Application No: R/176/20/HH
Site Address: 6 Ruston Avenue Rustington BN16 2AP
Description of works: Erection of new 1.8m high garden wall to side frontage facing Ruston Avenue

Thank you for your internet representation made on 22nd October 2020 which has been recorded as an objection with the comments as follows:

DRAWING NO.:
JW01-01A

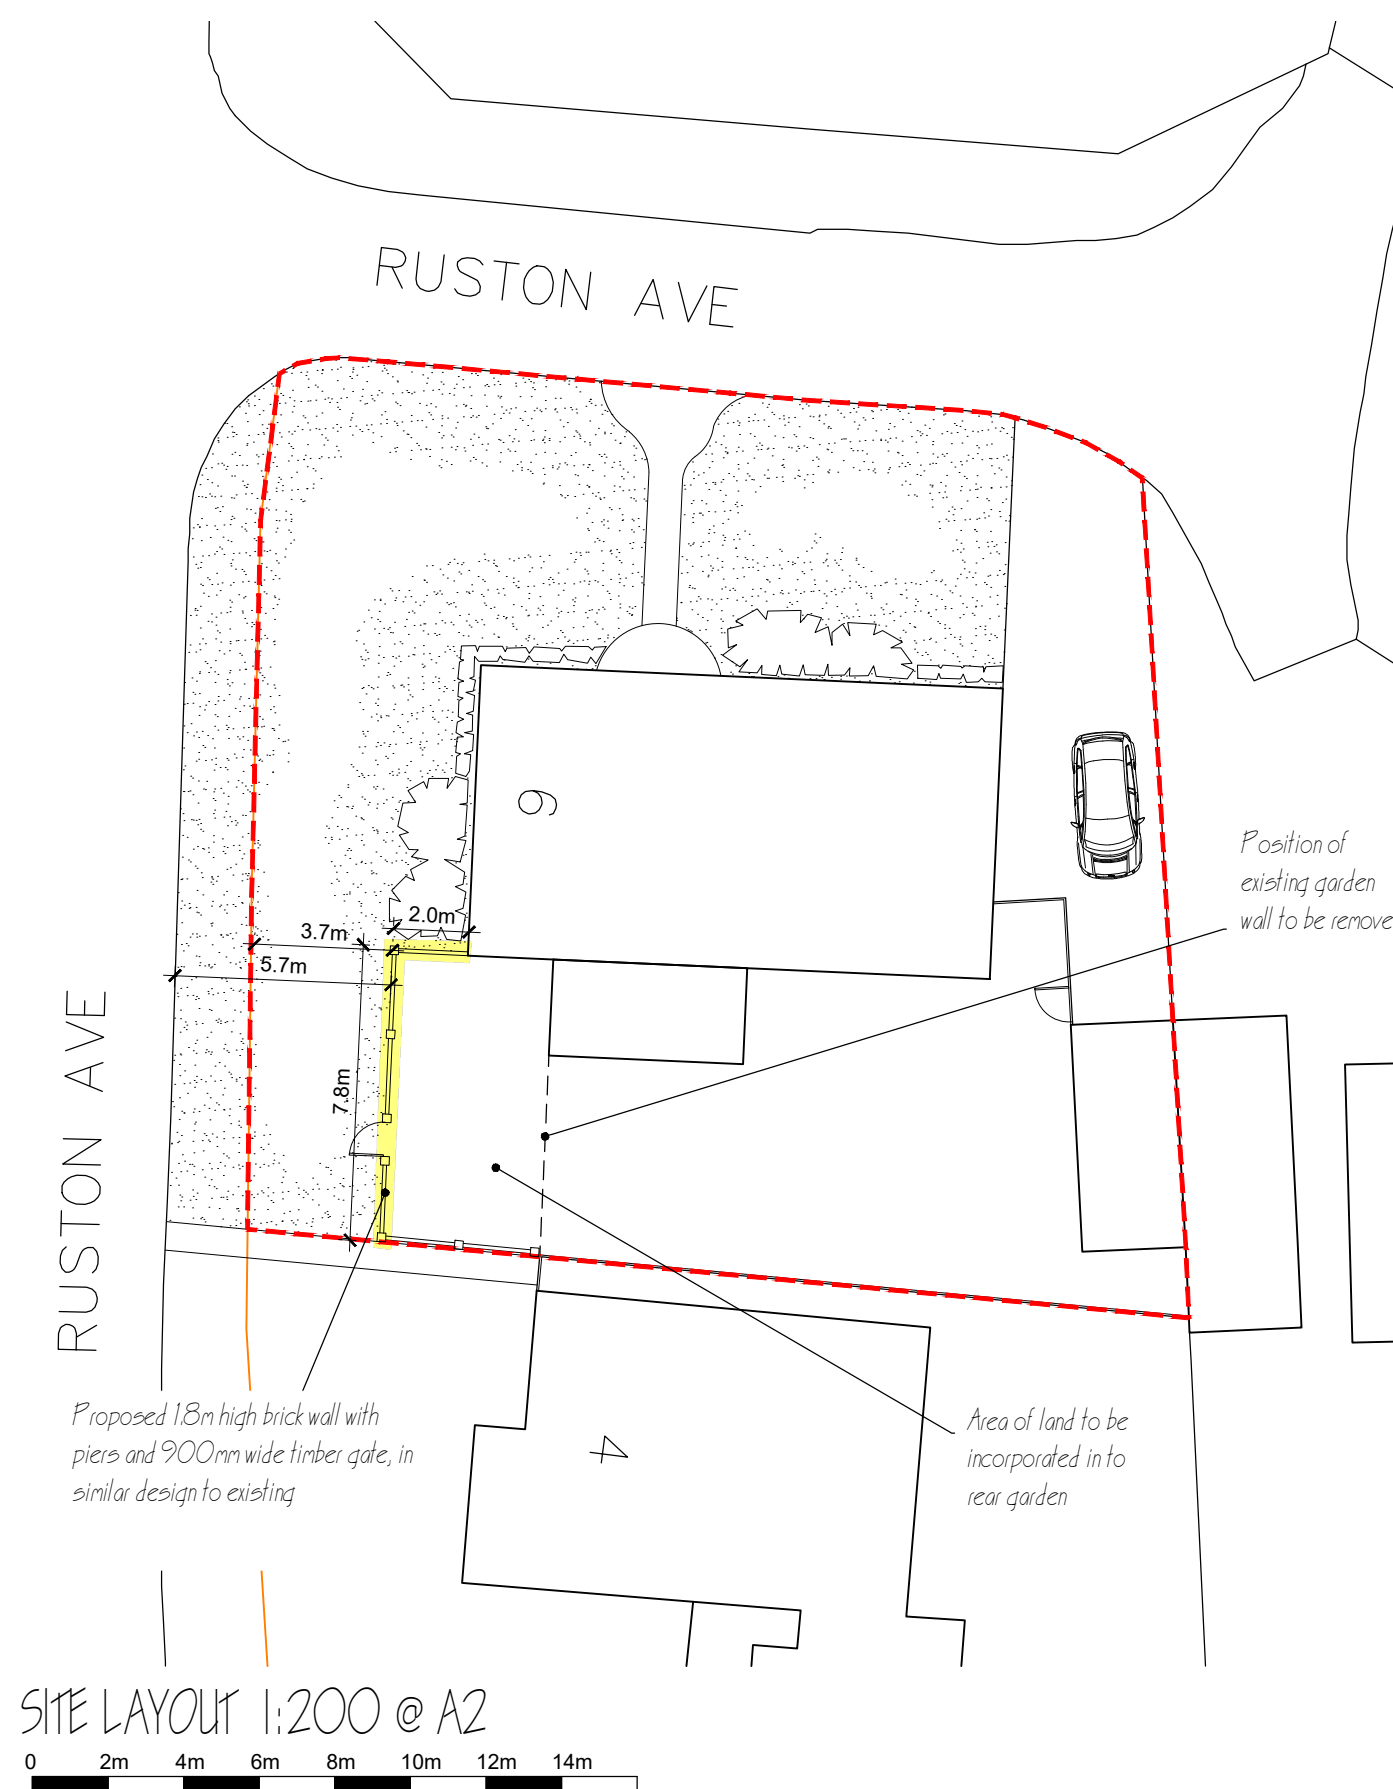
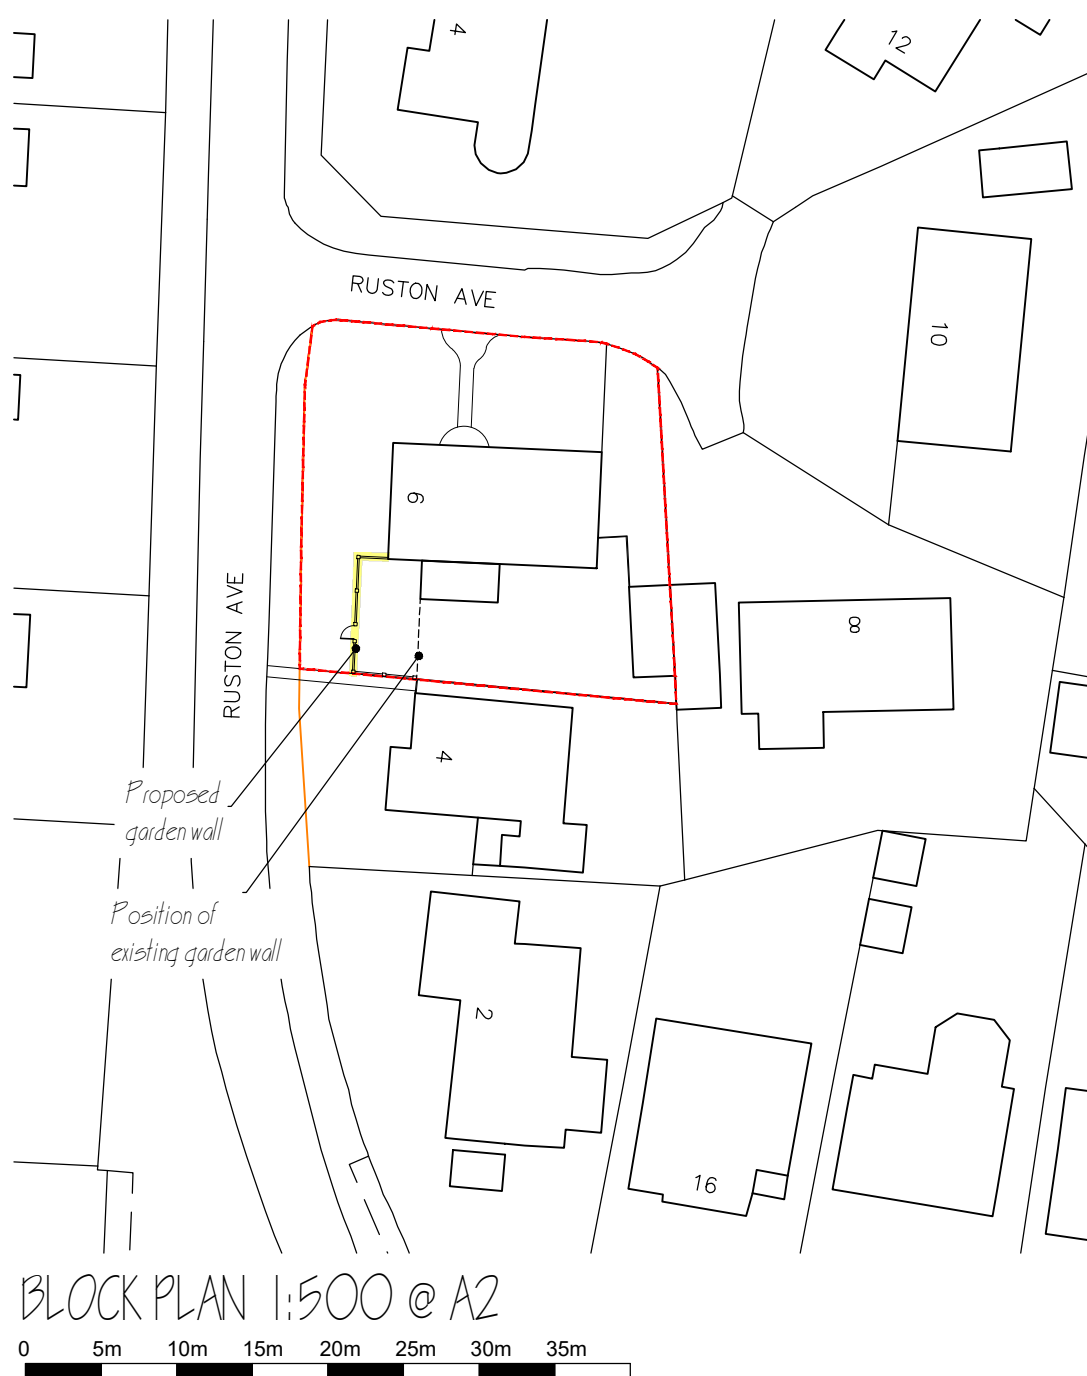
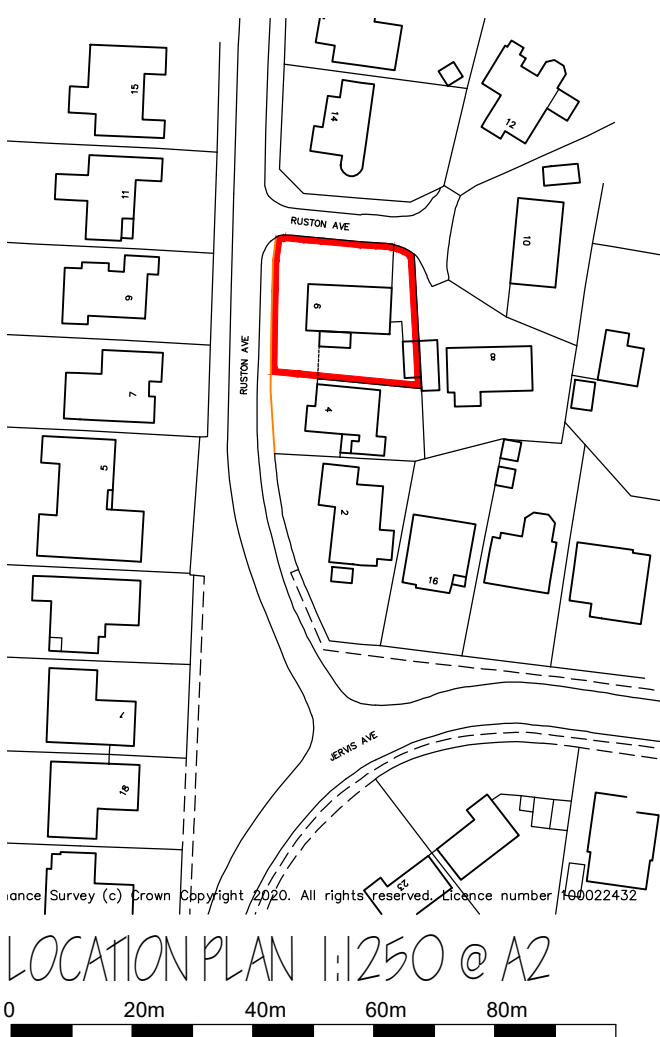
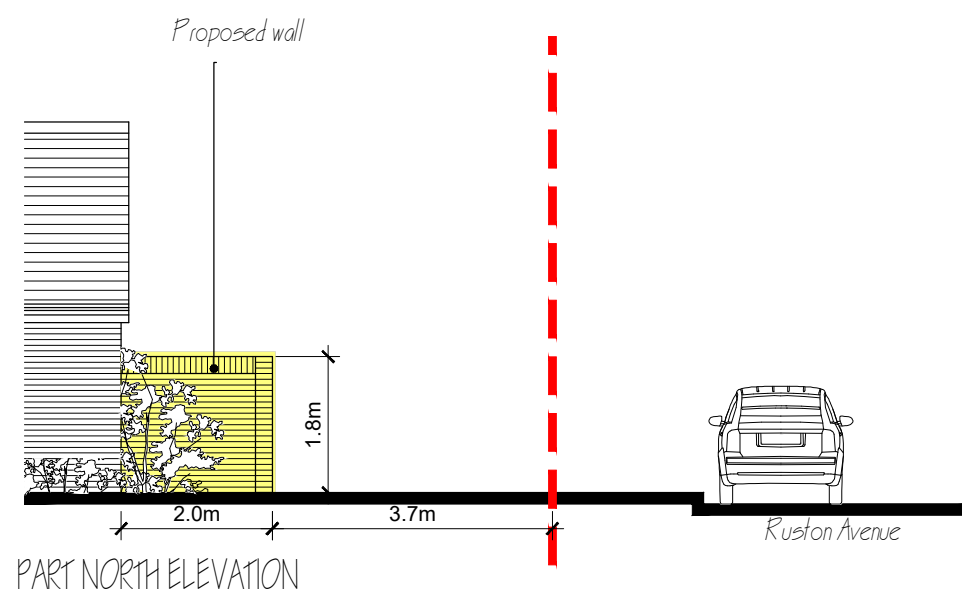
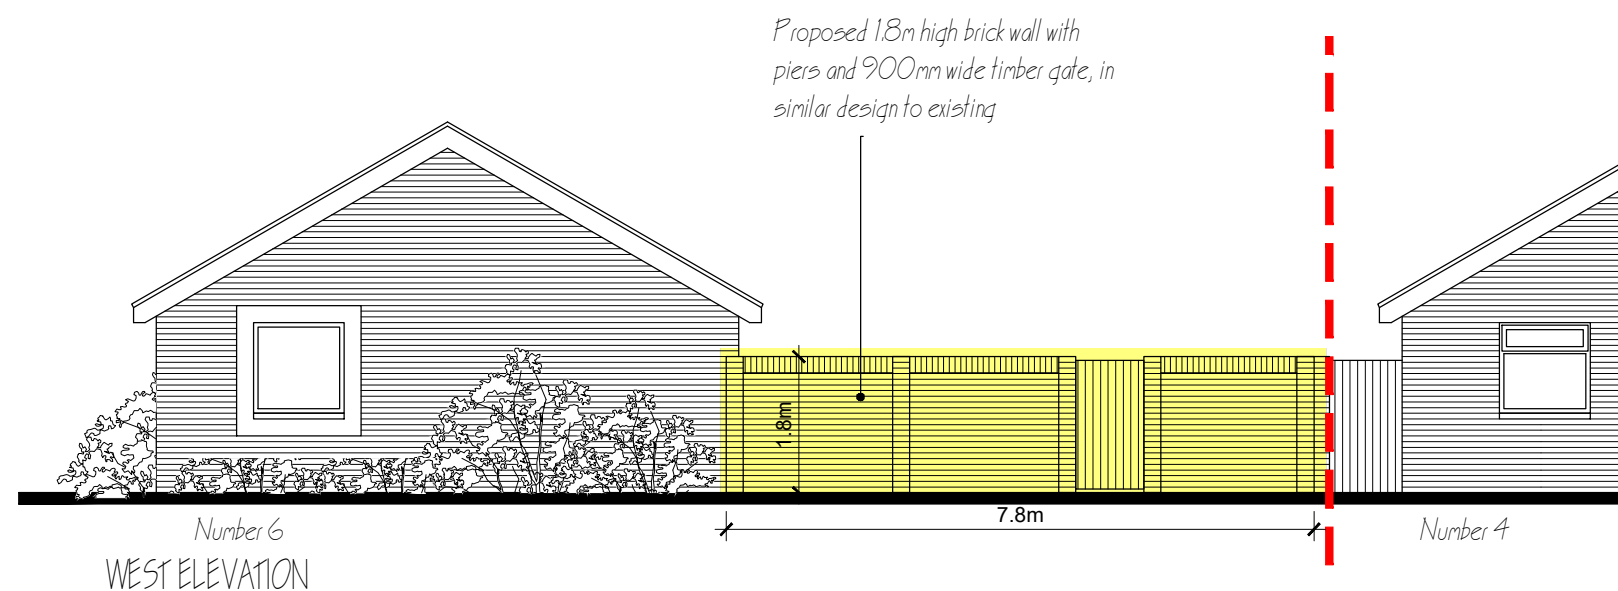
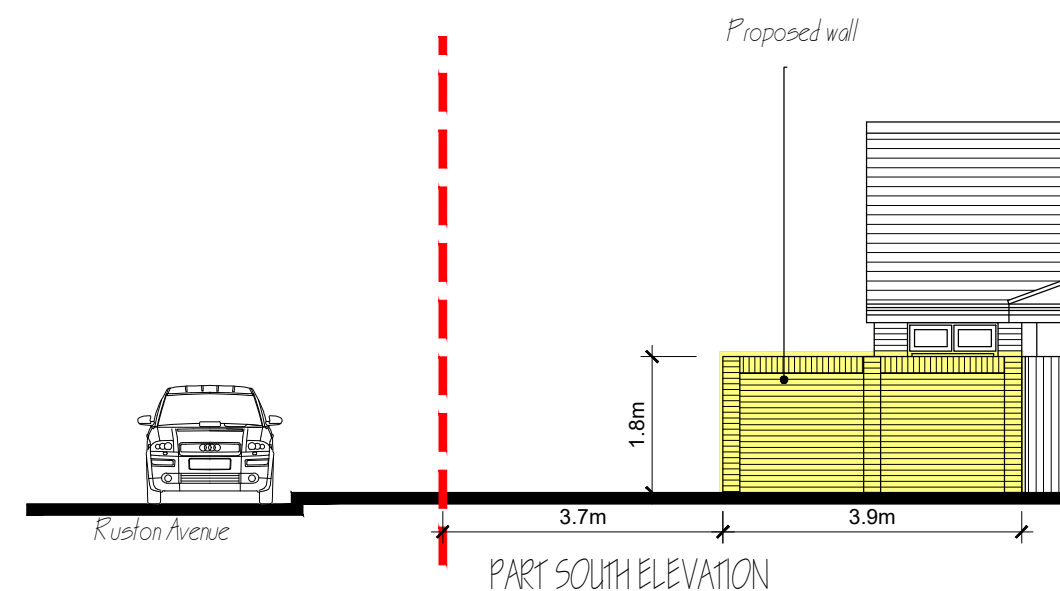
- Proposed wall alignment comes within 50mm of existing Inspection cover situated in path.
- There are no details given as to the preparation of subgrade and foundation of the boundary wall.
- With services running so close to the proposed wall alignment there is a risk of damage to private services during construction and may limit ease of inspection during operation phase.

- The drawings appear to hide the proposed section of wall running west to east with no dimension called up on plan and the hatch shown terminating at the southern corner.
